# **The Keadby Next Generation Power Station Project**

Planning Inspectorate Ref: EN0110001

## **Statement of Common Ground with National Highways**

12 February 2025

**Plate 10.2: HGV Designated Route Plan (Proposed Development Construction)**

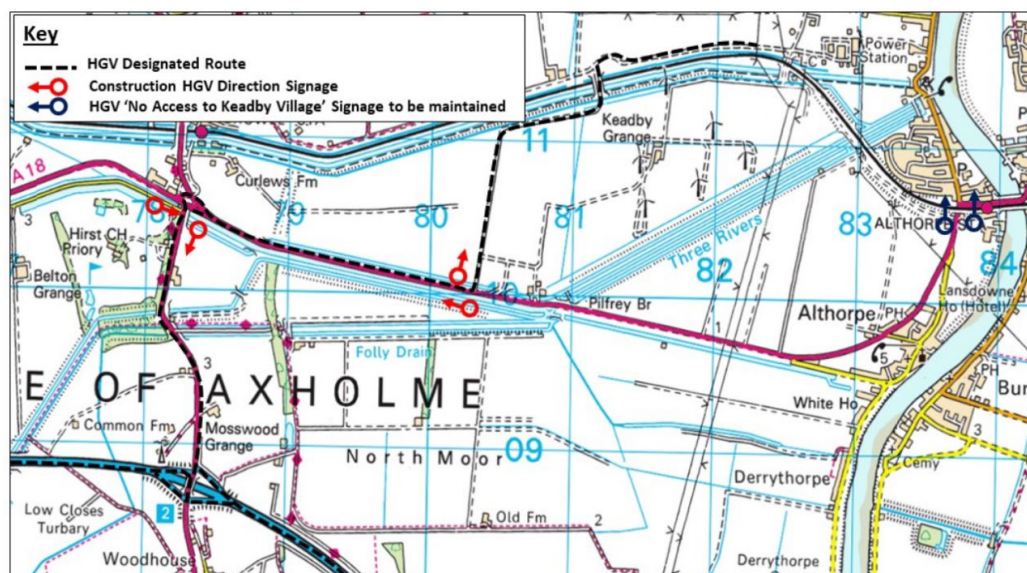
The Applicant assigned HGV trips to the M180 Junction 2 via the A18 and the A161. The construction workers trips assignment has been based on the geographic split of population within a 45 minute drive-time of the Proposed Development Site. National Highways would request that a detailed methodology be presented for review.
